Rezoning Transportation Analysis

Petition Number: 2021-092

| Date | Description |
|------------|--------------------|
| 08-23-2021 | Second Review (KP) |

TYPICAL SECTIONS

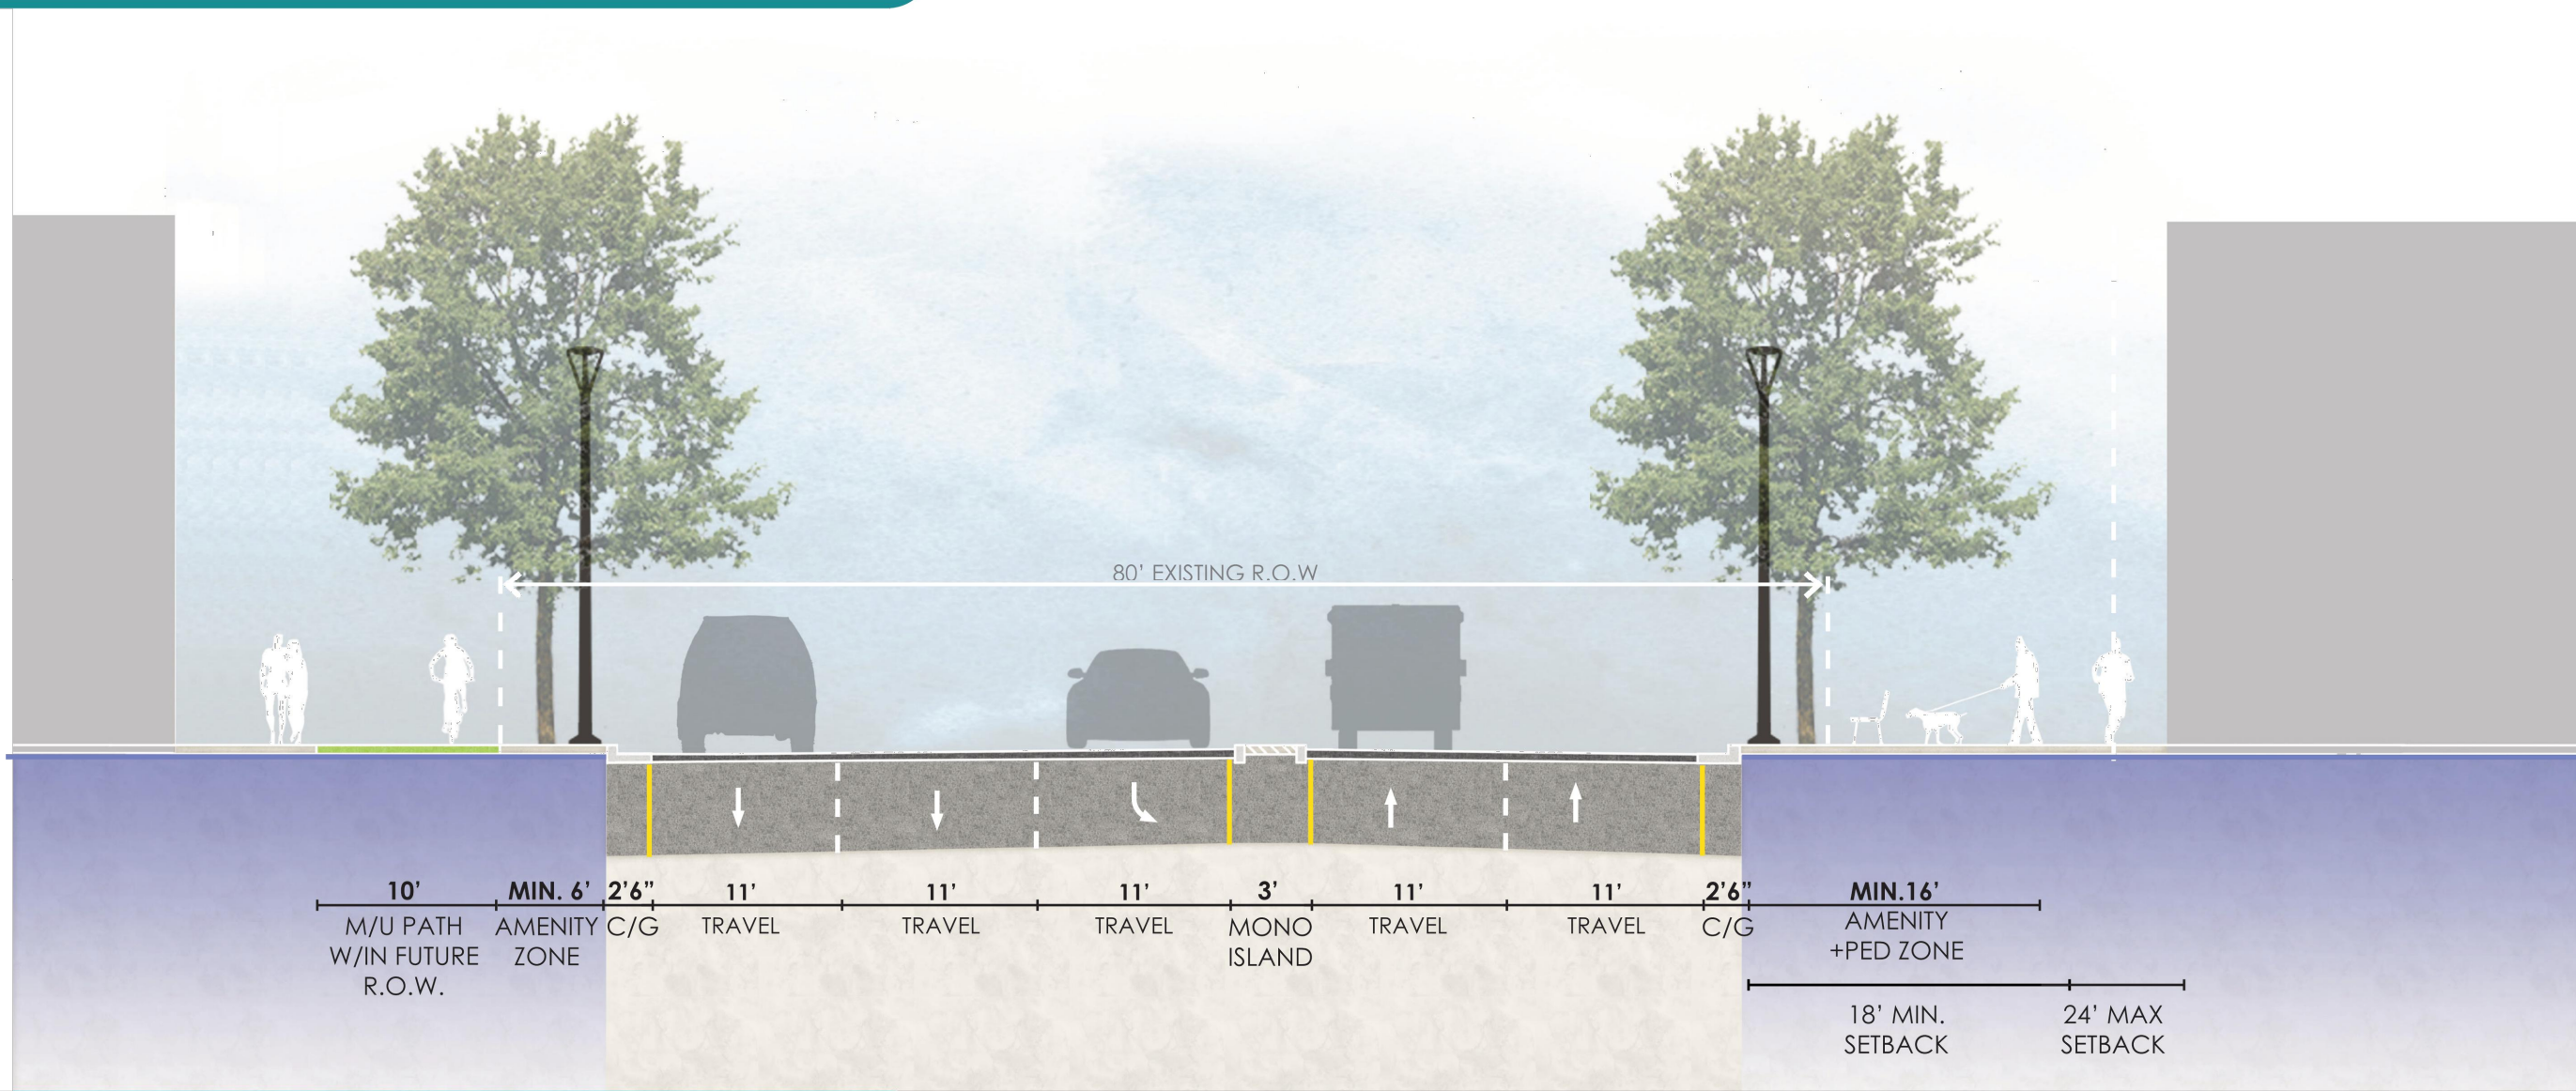
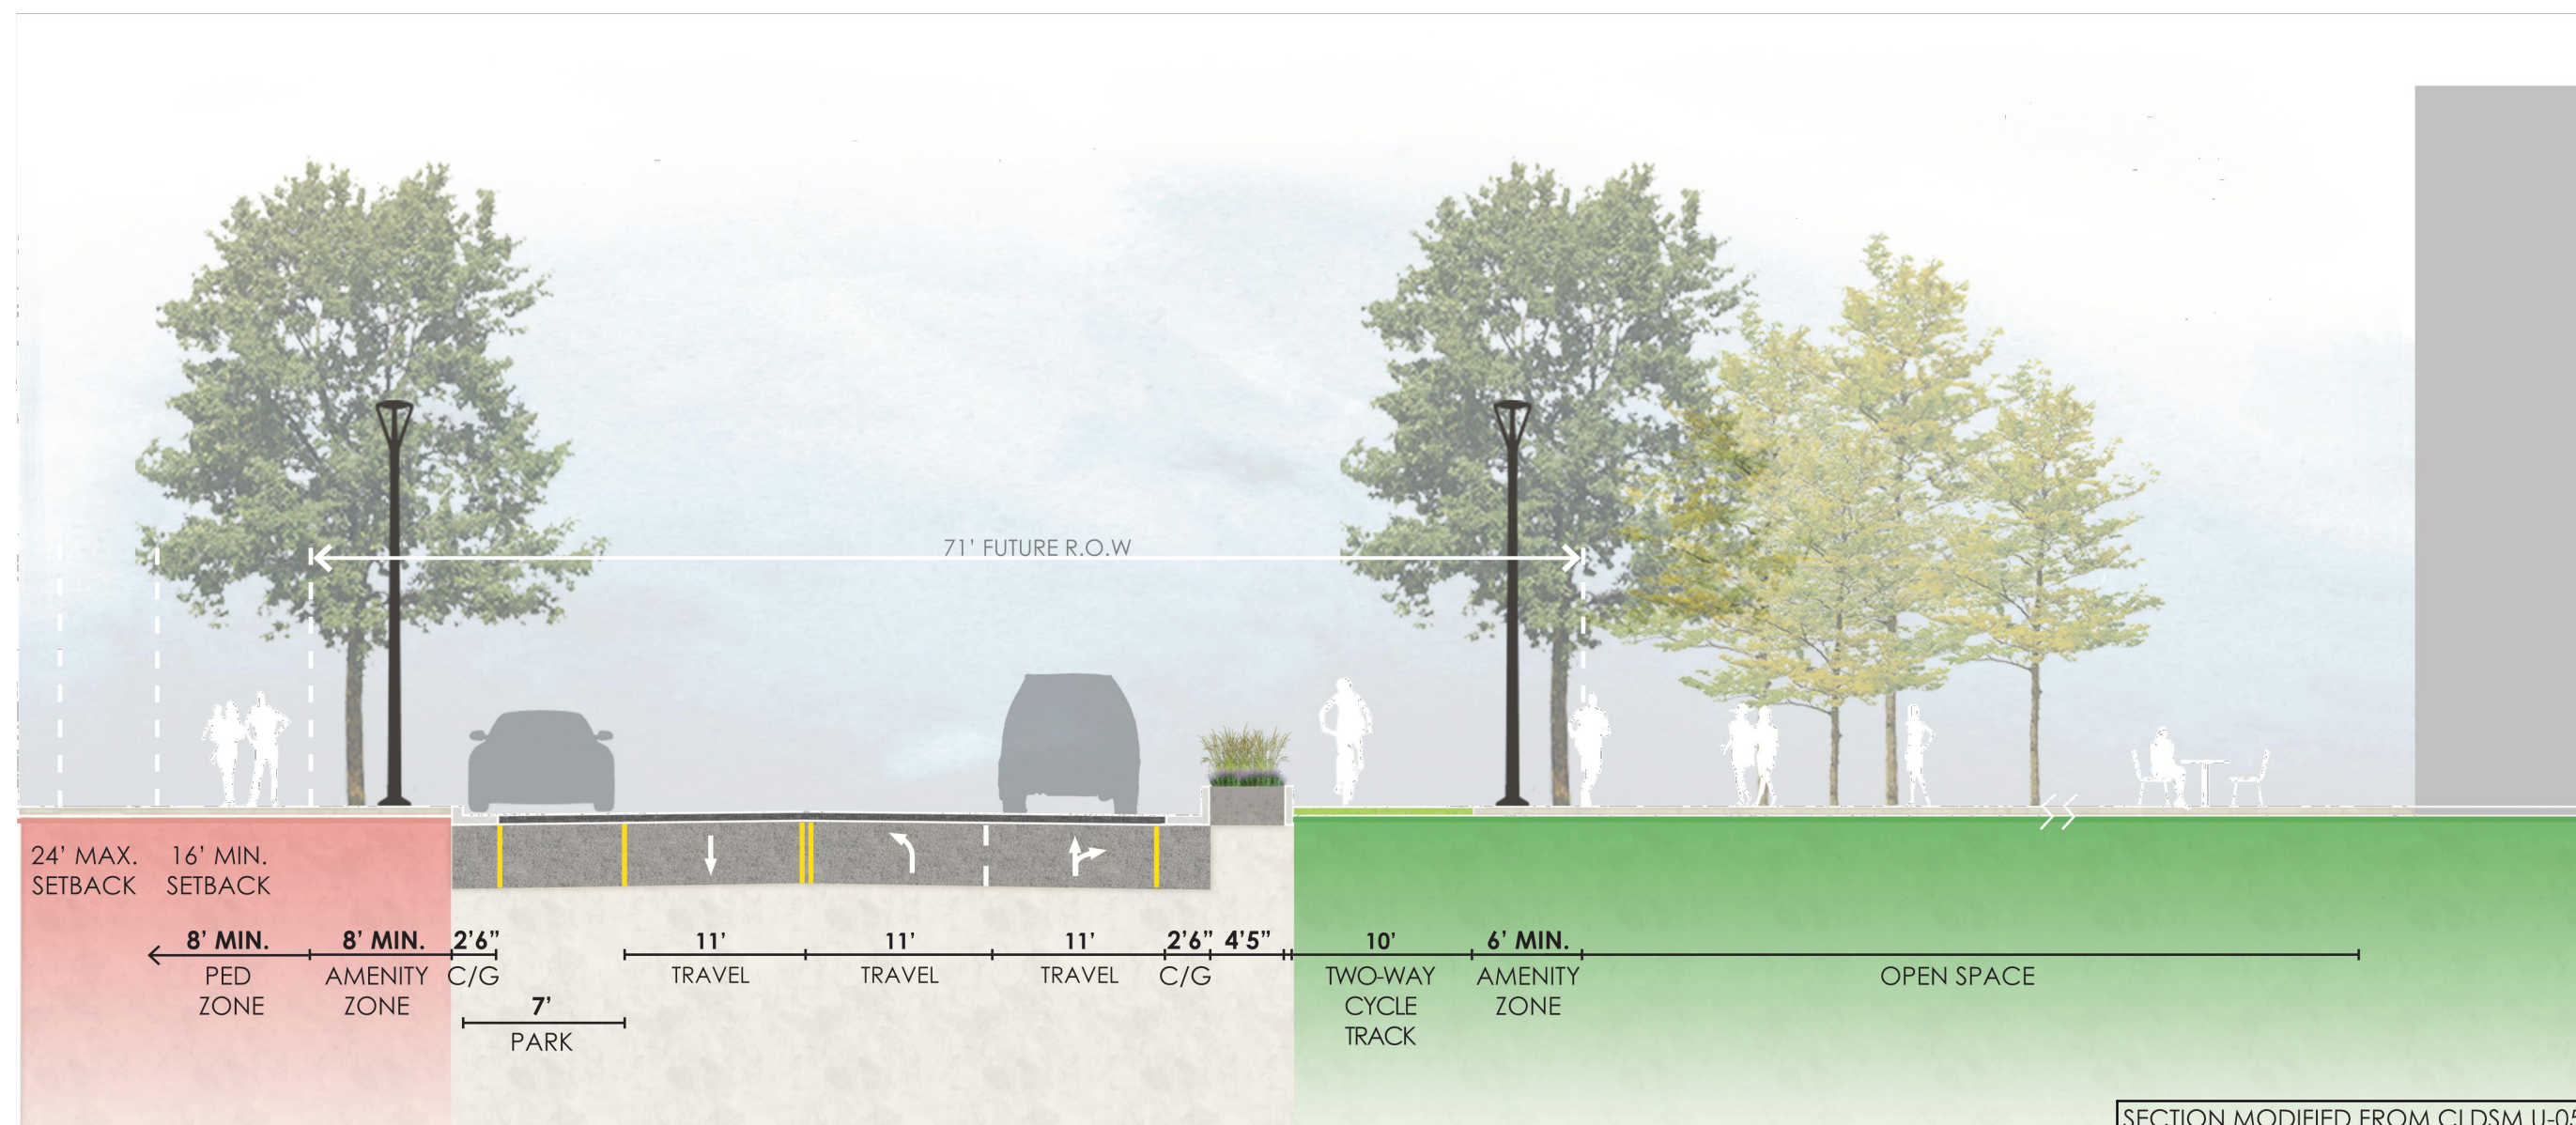
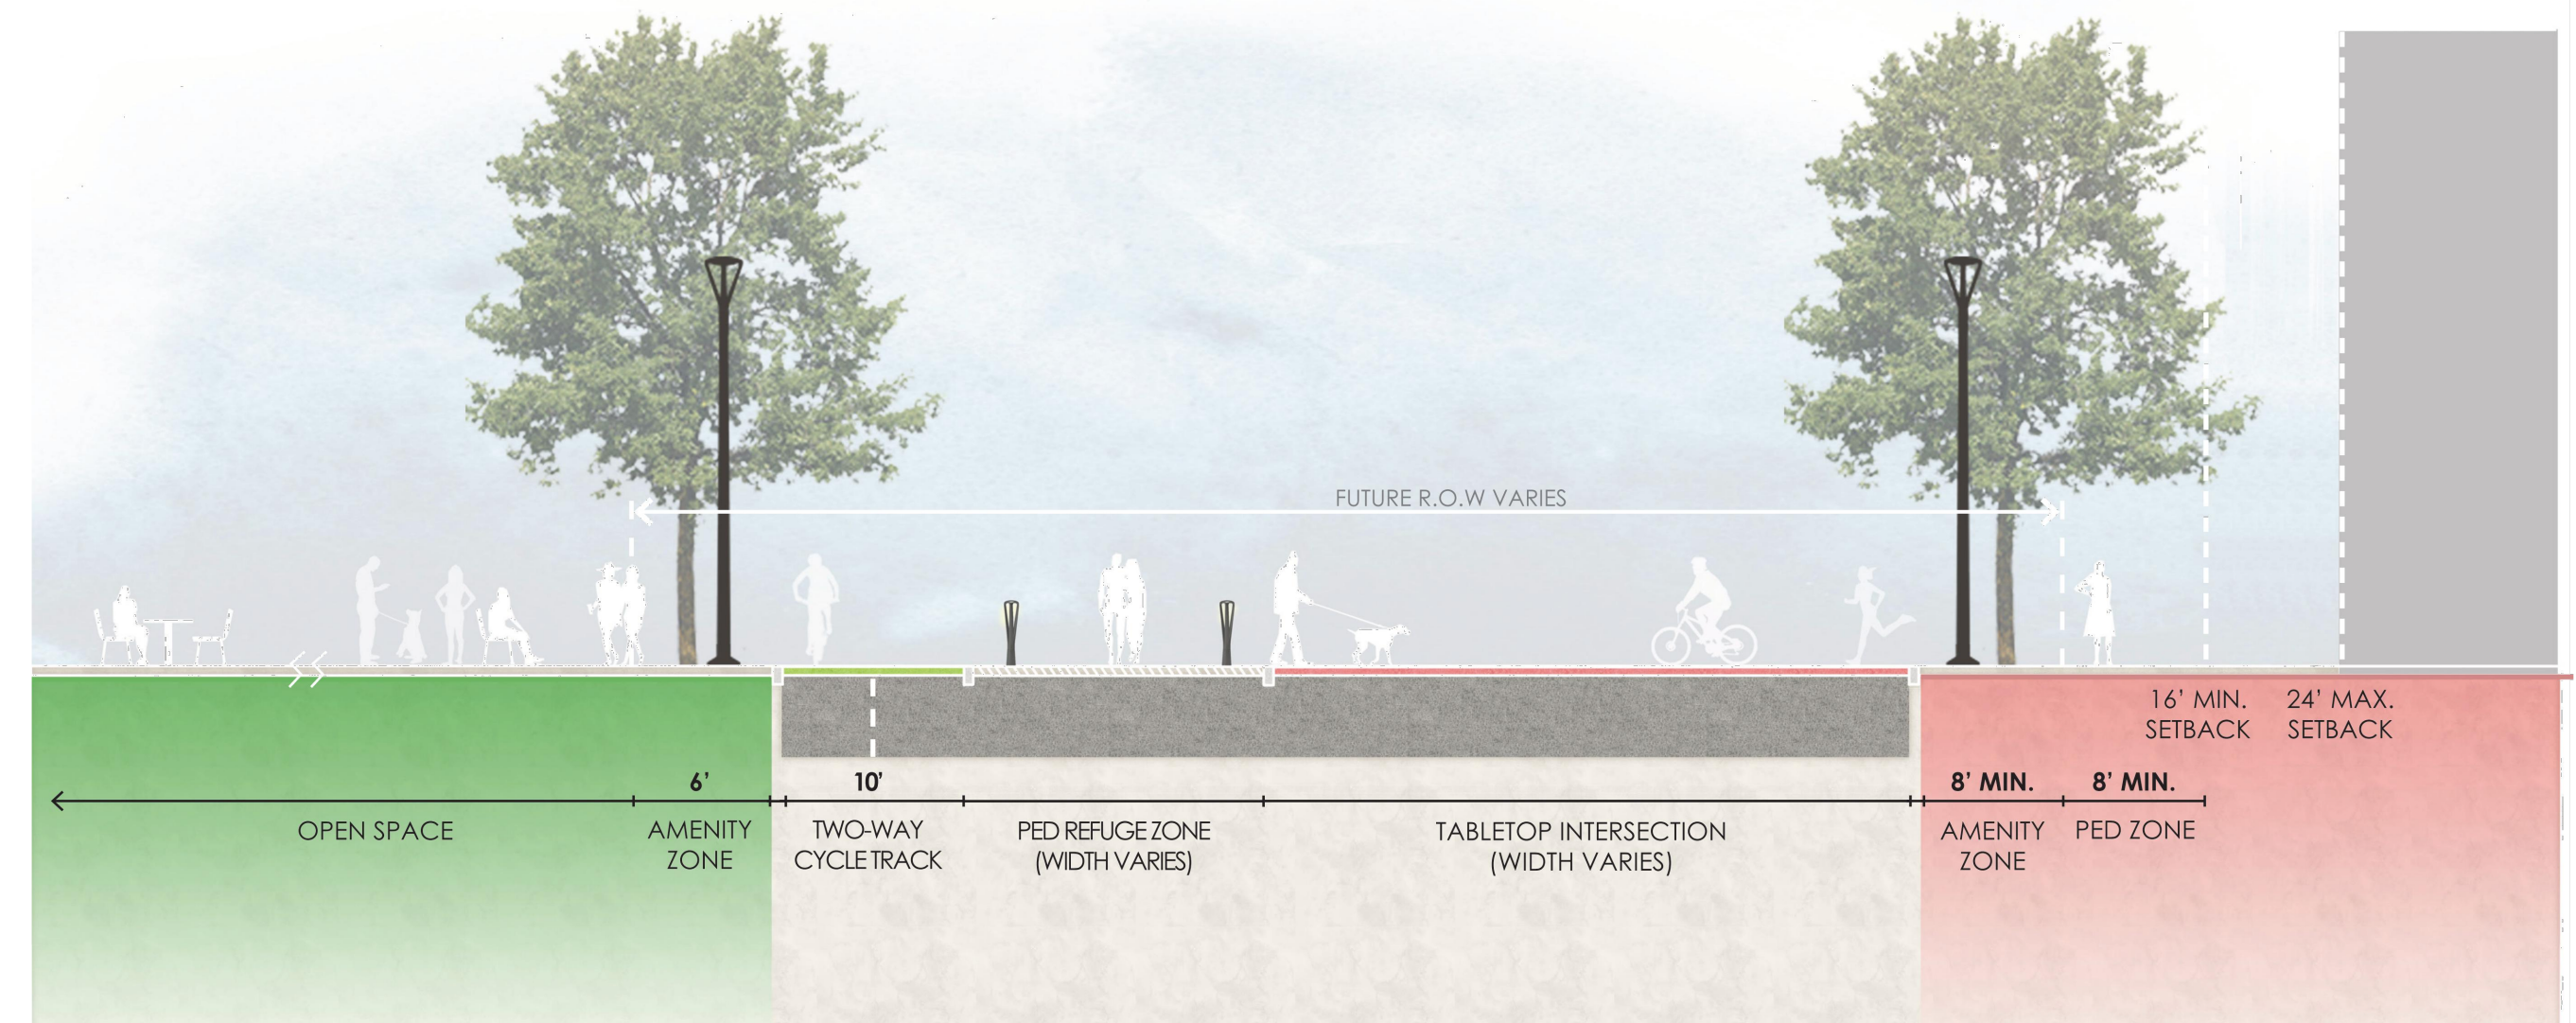
The proposed and existing back of curb location on Morehead Street must be labeled dimensioned from the existing centerline.

The proposed and existing Morehead Street right-of-way dedication must be labeled dimensioned from the existing centerline.
